# KIRKLEES METROPOLITAN COUNCIL INVESTMENT & REGENERATION SERVICE

### DELEGATED DECISION TO DETERMINE PLANNING APPLICATIONS

| Site Address:         | 33, Thorpe Lane, Almondbury, Huddersfield, HD5 8TA                                                                                                                                                                                               |
| Description:          | First floor extension to existing dwelling, single storey extension to rear, creation of raised patio with access steps, single storey extension to front and detached garage to front including creation of associated hard standing and works. |

DWG TITLE Plans, Elevations and Views as Proposed

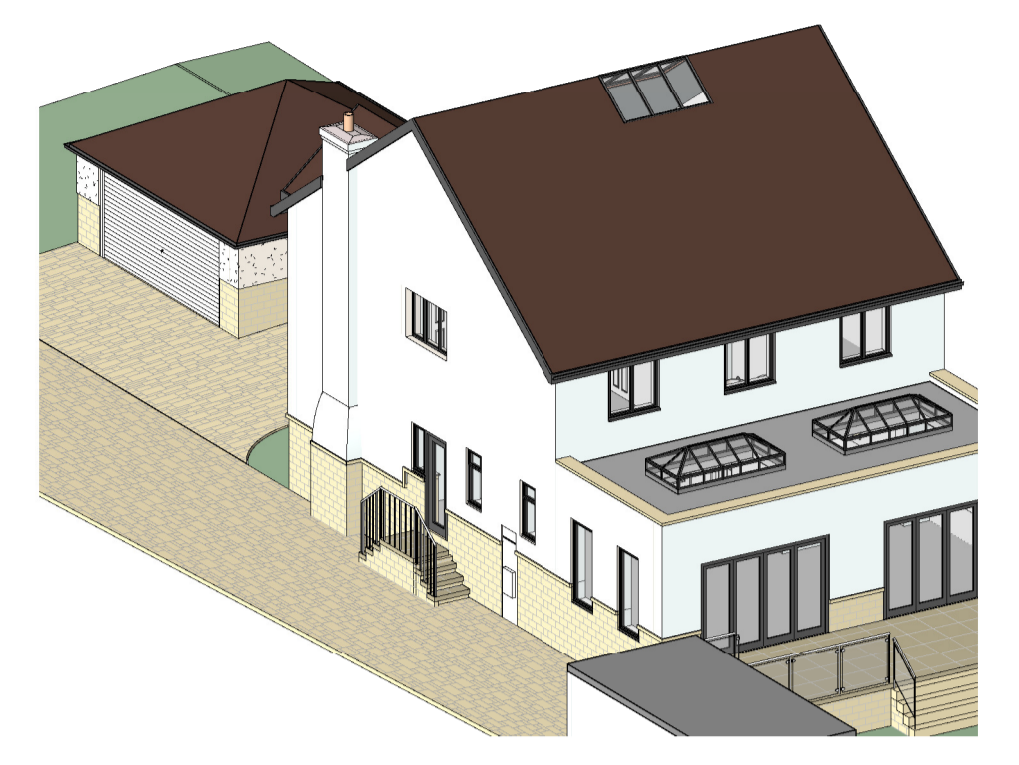
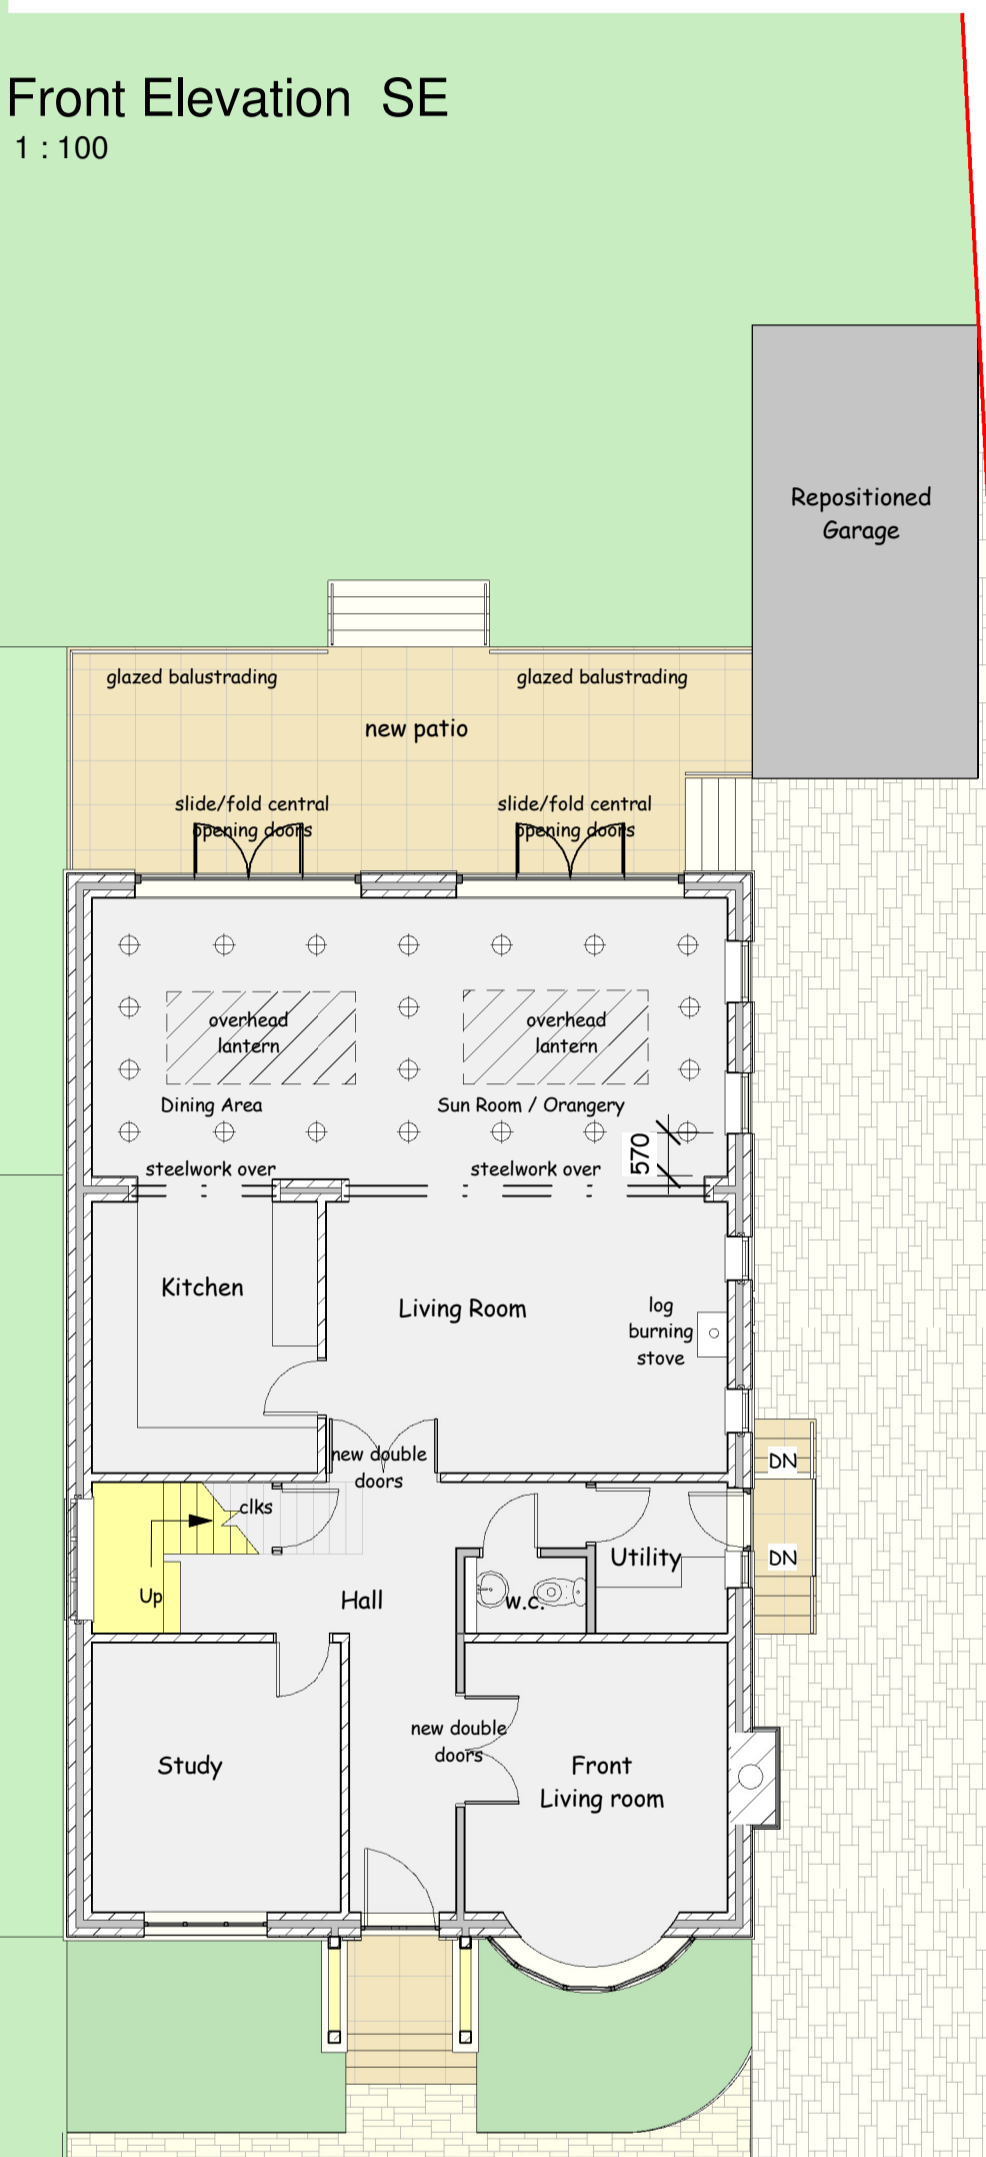
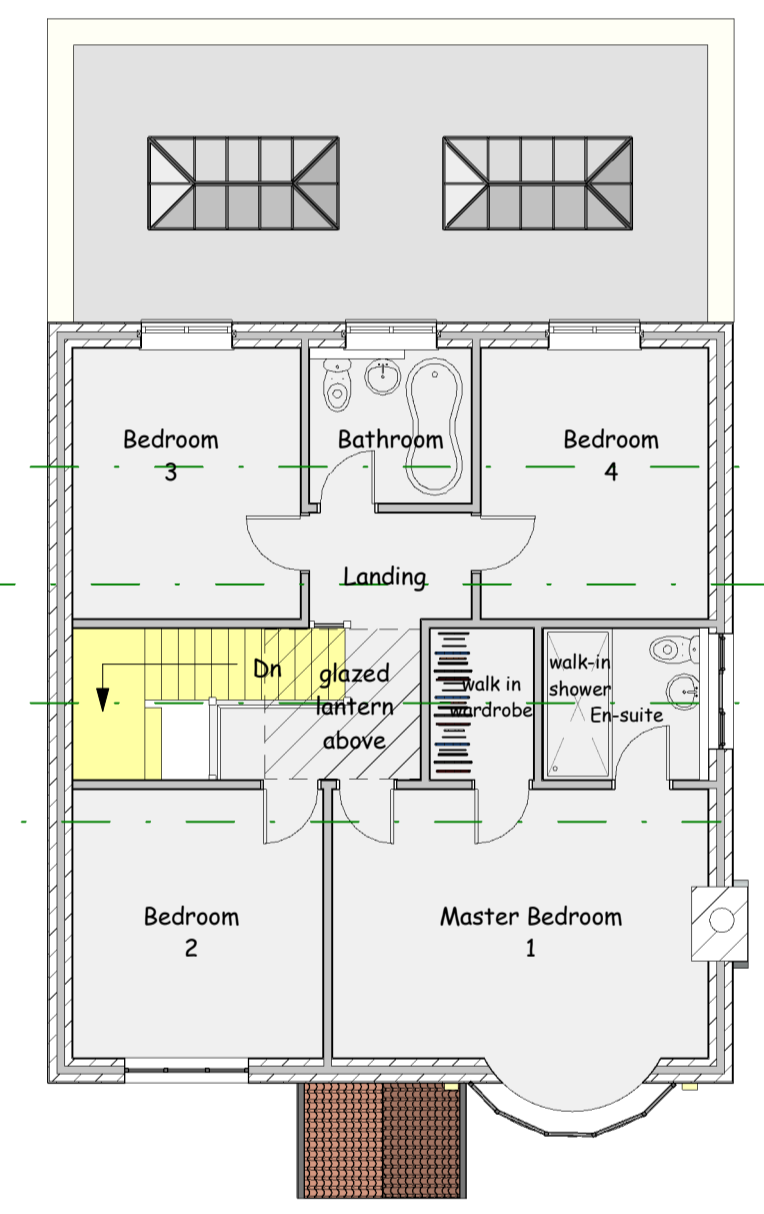
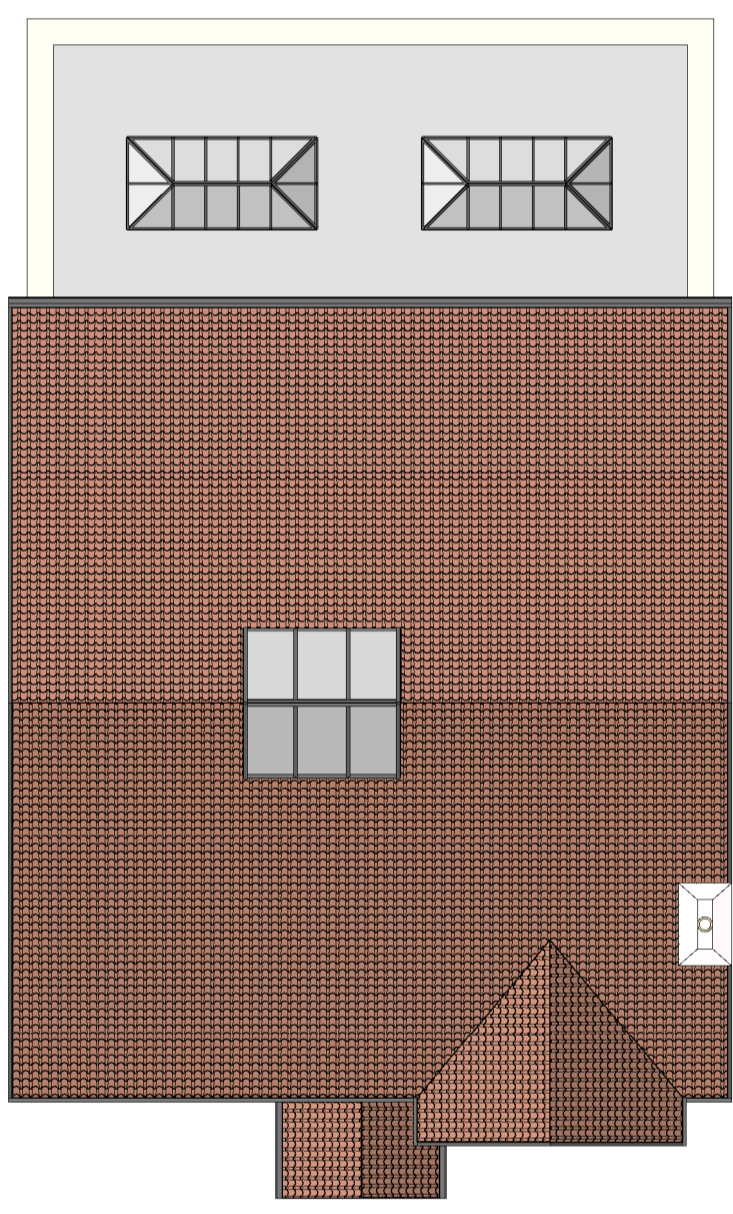
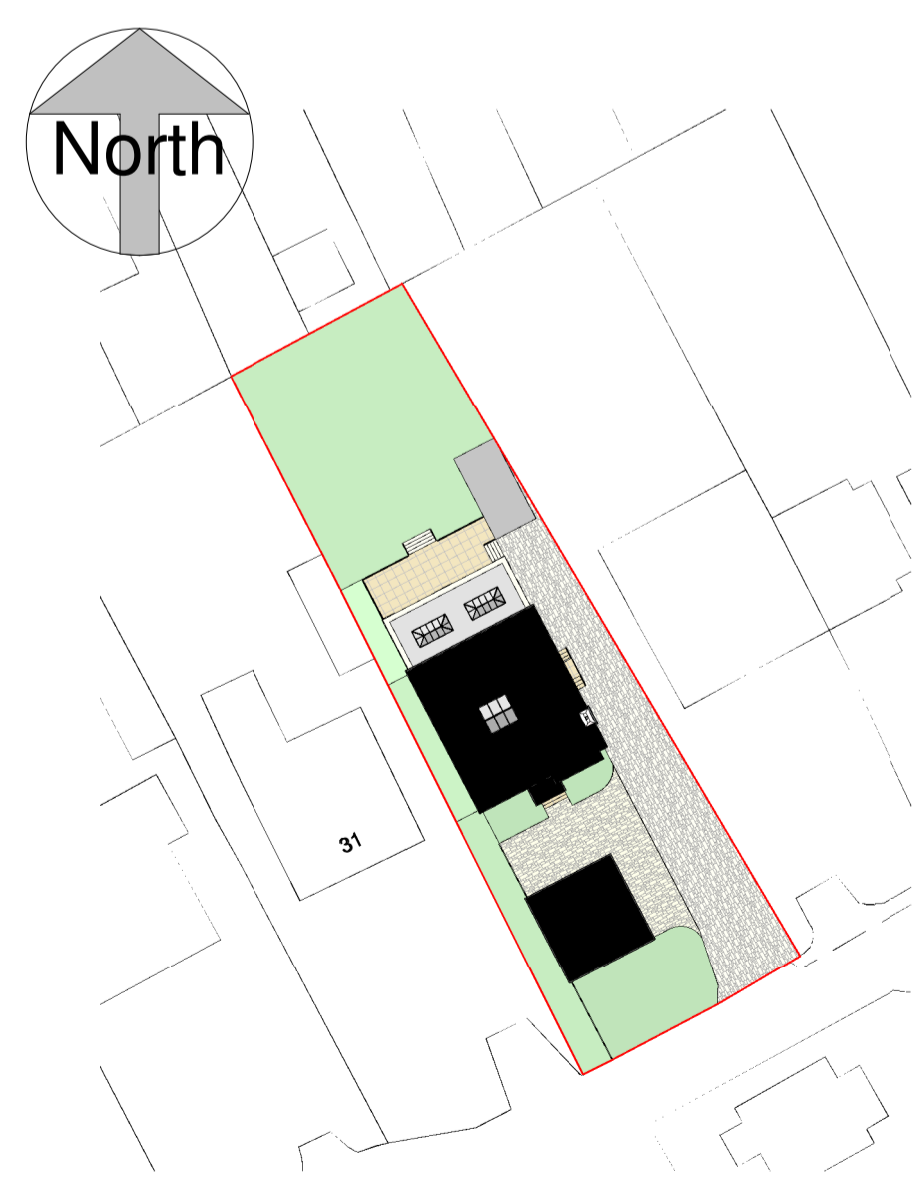
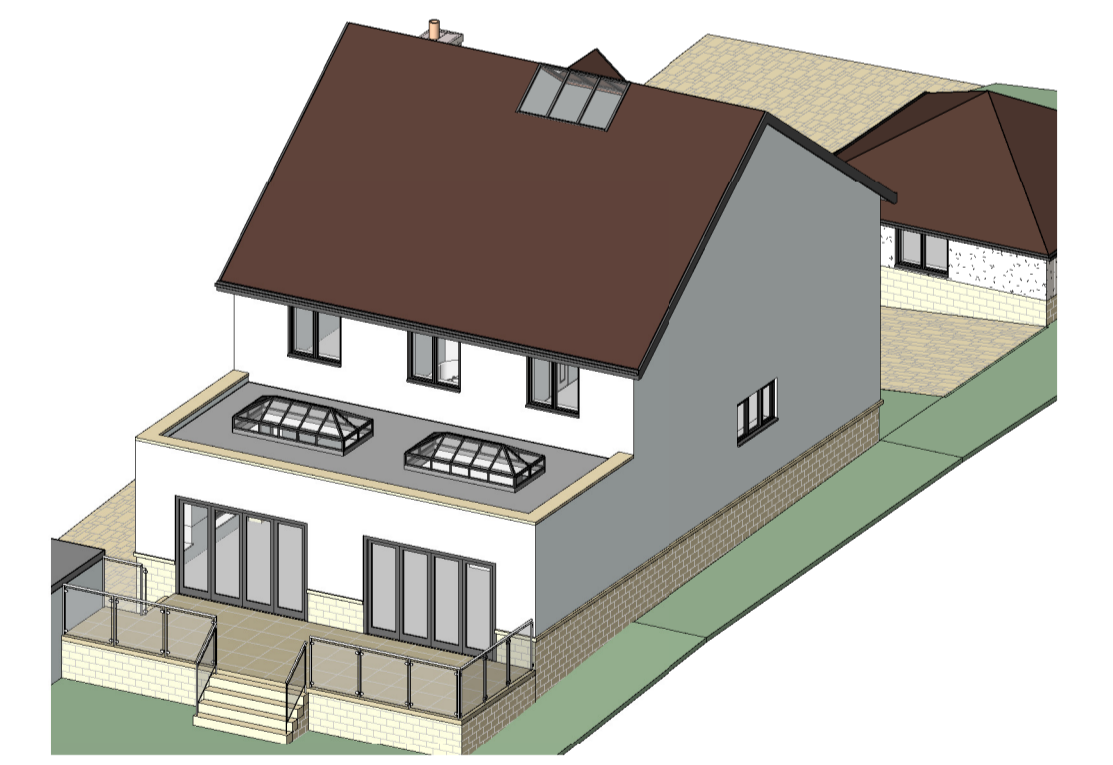
In this instance, it is considered that raising the ridge height of the bungalow to a two-storey level is acceptable, with other properties in the street scene two-storey in height, including those which directly neighbour No. 33 to the east and west.

The proposed first floor extension to No. 33 will take the ridge height to 8.9 metres. Given that the neighbouring properties to both sides of No. 33 have been calculated to have a ridge height of approximately 8 metres, it is not

The proposed single storey rear extension to No. 33 is considered to be of a size/scale which appropriately complies with the above guidance. The extension will have a projection of 4 metres and a height of 4 metres, with the property detached.

The proposed front extension to No. 33 is of a small size/scale, with open sides above a small stone base. It would be well set back from the streetscene and would be read as a subservient addition.

The proposed detached garage is considered to be of a subservient size/scale, when read against the proposed two-storey property. It will preserve more than 50% of the garden space at 33 Thorpe Lane, preserving the entirety of the private amenity space to the rear of the property.

The detached garage would be set back 6 metres from the front boundary of curtilage and the topographical levels of the site mean that the garage would be set down, reducing its overall bulk / massing when viewed from the fronting highway of Thorpe Lane. It is noted that the front curtilage of the site is considered to be of a scale to support the erection of the proposed detached garage, retaining an open feel with areas of both soft and hard landscaping.

No habitable room glazing is proposed on the side elevation facing towards No. 31 and the proposed raise terrace will be adjacent to the detached garage within the curtilage of this neighbouring property. Therefore, it is not considered that the proposal would result in any undue impacts of overlooking for the occupiers of No. 31 Thorpe Lane.

The side windows to serve the living room on the elevation adjacent to No. 35 are existing. The rear extension proposed glazing on the same side elevation, given that these are considered to be secondary windows to serve the extension, with large, glazed doors on the rear elevation, upon any grant of approval, a condition shall be imposed to obscurely glaze the side windows, for reasons for retaining appropriate levels of residential privacy.

With regard to the proposed raised terrace, this is to be raised 0.8 metres above ground level. The section of patio accommodating the steps and opening area for the rear glazed doors is situated adjacent to No. 35, with no screening. The predominant functional area of the raised terrace is screened by the repositioned garage. Therefore, on balance, given the extent to which the terrace will be raised, and the layout proposed, it is not considered that it

3. The development shall not be occupied until the windows in the eastern (side) elevation of the single storey rear extension hereby approved have been obscure glazed. The obscure glazing shall thereafter be retained for the lifetime of the development.

Garage Elevation NE
1 : 100

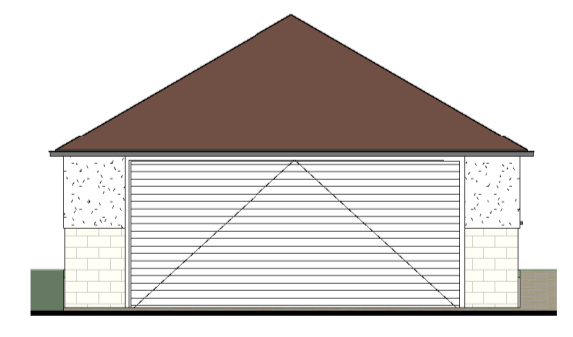
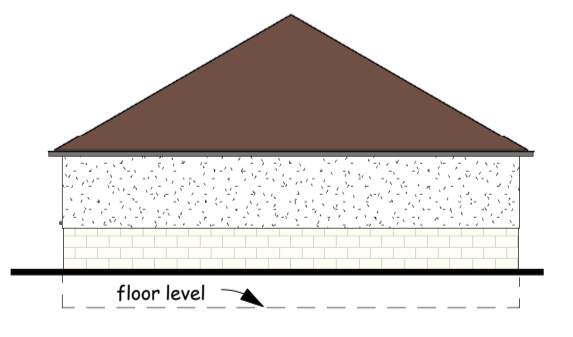
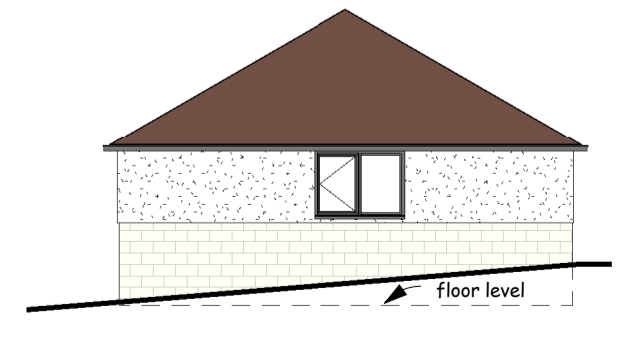
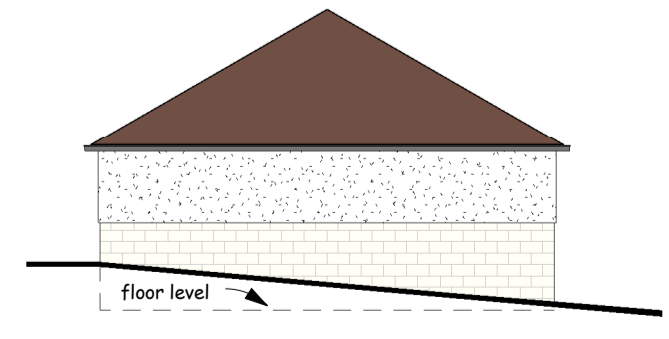
Whilst it is noted that the detached garage would be erected to the front of the dwelling, rather than being set back behind the building line, it is considered that, based on the individual merits of the proposal and application site, this is an acceptable siting in this instance.

With regard to the proposed detached garage, the Trees Officer concluded that, whilst it would appear that this development would be located outside of the root protection areas of the protected tree to the west, it is not possible to confirm such a conclusion without the submission of a Arboricultural Impact Assessment. However, given the presence of retaining walls and a driveway, separating the two properties, it is assumed that the tree roots would not affect the area to site the proposed detached garage. Therefore, on balance, the proposal is considered to be acceptable with regard to trees.
